**Portland Property Holdings, LLC
2 Main Street
Topsham, Maine 04086
207-865-4323**

July 21, 2014

Re: Request to Amend the Level III Site Plan and Traffic Movement Permit granted on May 14, 2013
Commercial Development including gas station and convenience store with ATM
2282 Congress Street, Portland, ME – Proj. ID: 2013-086

Attachment: Amended Site Plan and Grading and Drainage Plan

SHEET TITLE: AMENDED GRADING AND DRAINAGE PLAN

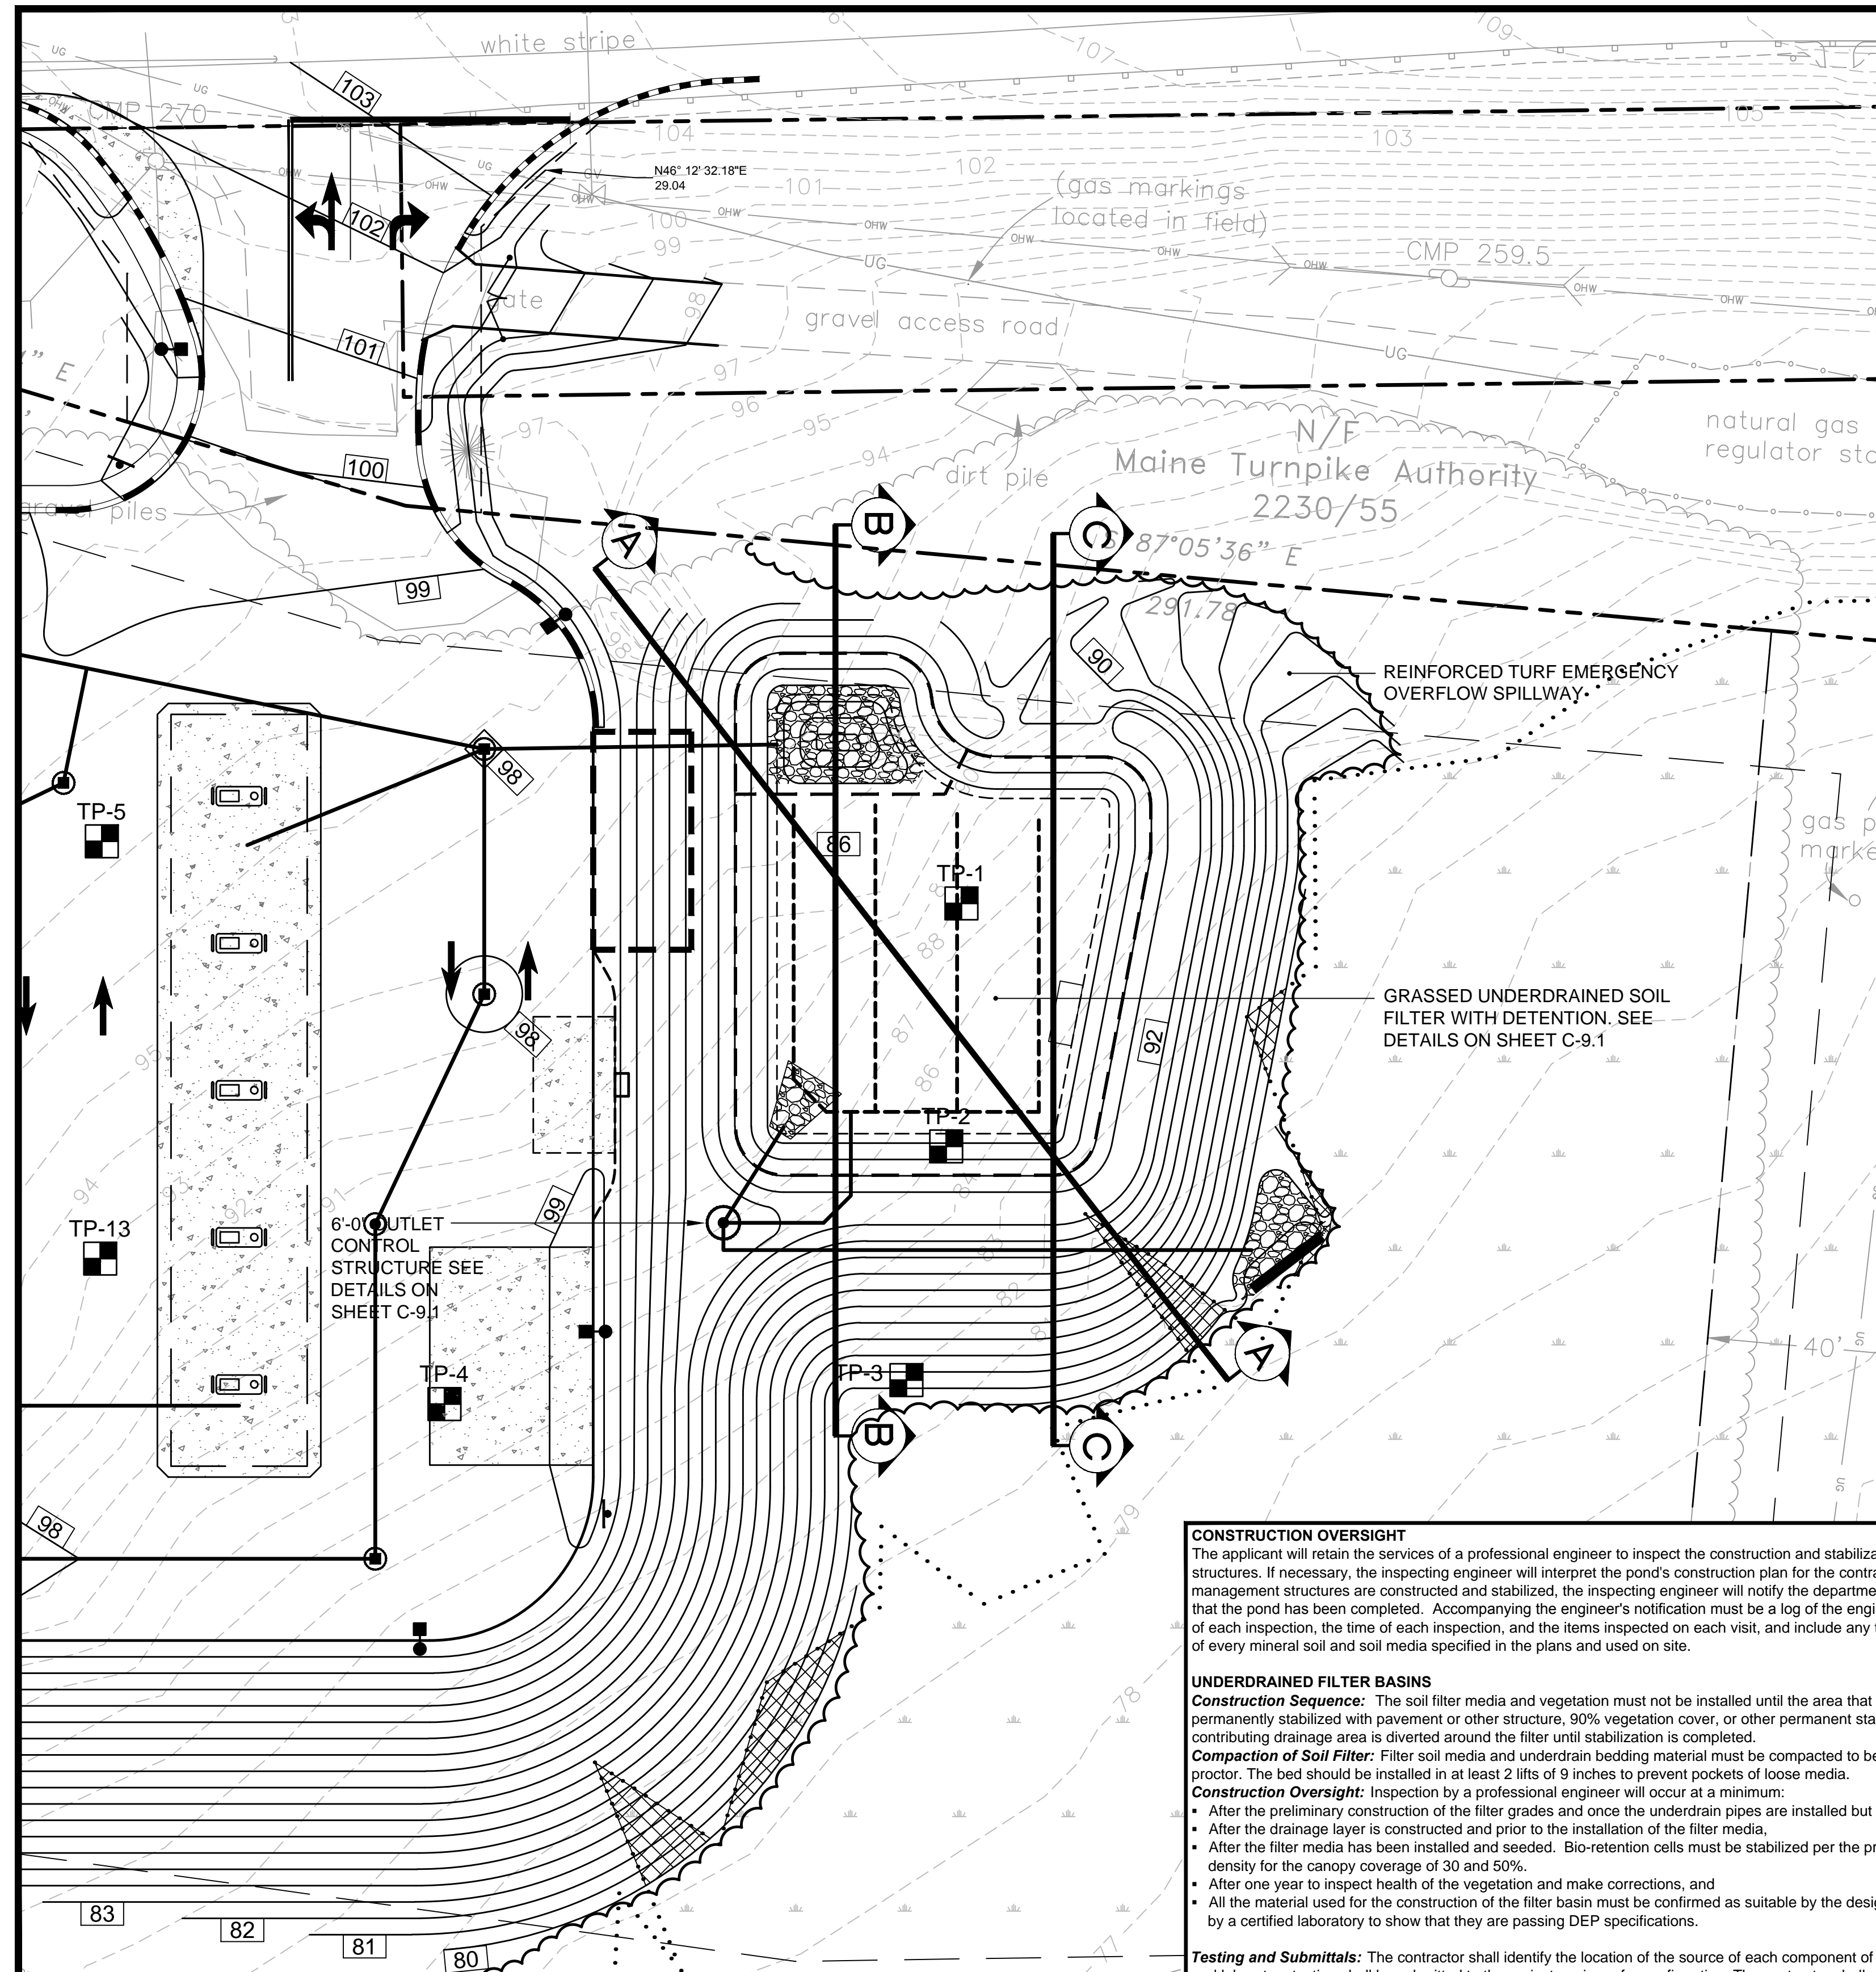
Our tenant has reevaluated this local market area and has determined that there is a greater demand for diesel from small to mid-size vehicles as opposed to tractor trailers. Therefore, the stand alone, high speed diesel pumps are not required and diesel can be incorporated into the two end dispensers of the reconfigured dispenser island. To accommodate the diesel vehicles, the dispenser layout has been changed from 6 stacked dispensers to 5 “dive” in dispensers.

The building size and location and the parking lot circulation have not changed. The parking spaces at the far end of the site have been relocated to the ATM side of the building. Tractor trailers can still circulate around the property as evidenced by autoturn figures that will be made part of the submission package.

The elimination of the strand alone diesel pumps allowed us to slightly reduce the overall development by moving the eastern pavement line in approximately 55 feet. Accordingly, the site development activities, including the stormwater management system, benefits from a reduction in size and scale. The following is a summary of the resulting minor site plan revisions:

May 2013 Original Plan	July 2014 Amended Plan	Reduction
Developed Area	2.25 acres	2.14 acres	0.11 acres
Impervious Area	1.57 acres	1.19 acres	0.38 acres
Fuel Dispensers	6 plus 2 diesel	5 w/ diesel included	3 dispensers
Parking Spaces	26 plus 14 at the dispensers	27 plus 10 at the dispensers	3 spaces
